## **Application by National Highways for the A46 Newark Bypass**

### **The Examining Authority's written questions and requests for information (ExQ3)**

**Issued on 12 March 2025**

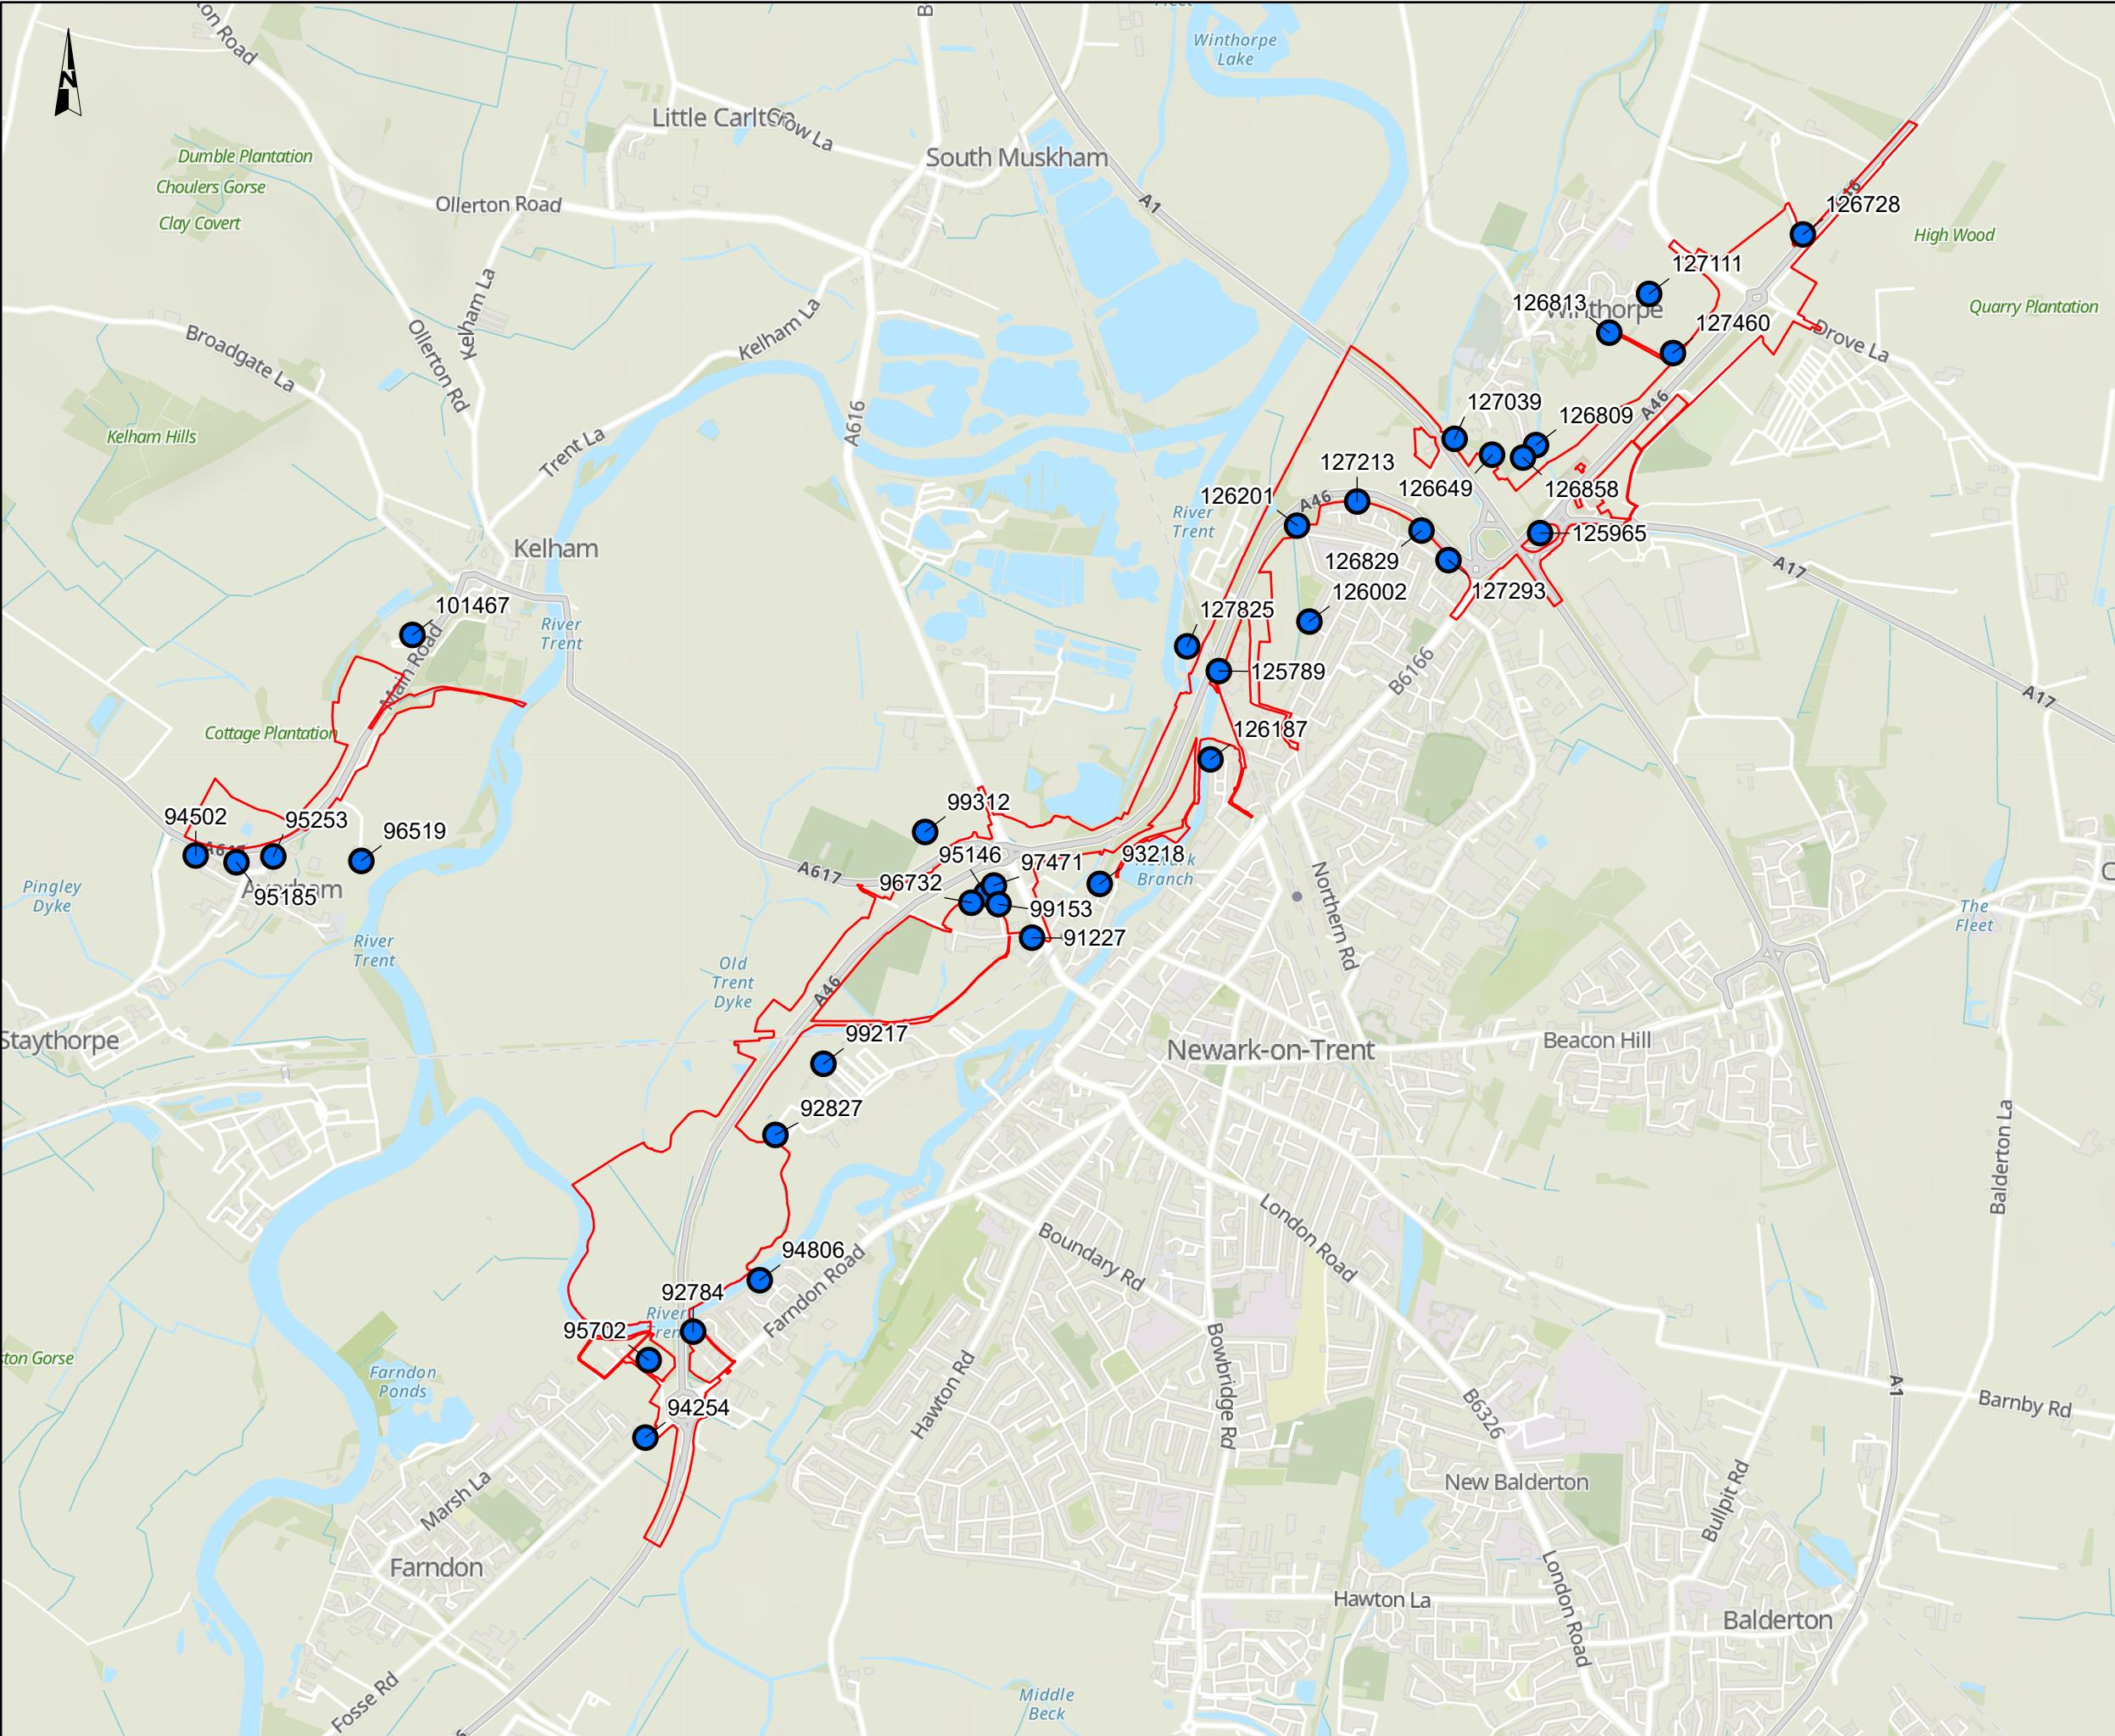
ExQ3	Question to:	Question:
12. Noise and Vibration		
Q12.0.1	The Applicant	<b>Figure 11.11</b> Please update Figure 11.11 <a href="#">[AS-065]</a> with a label showing the location of 95146.
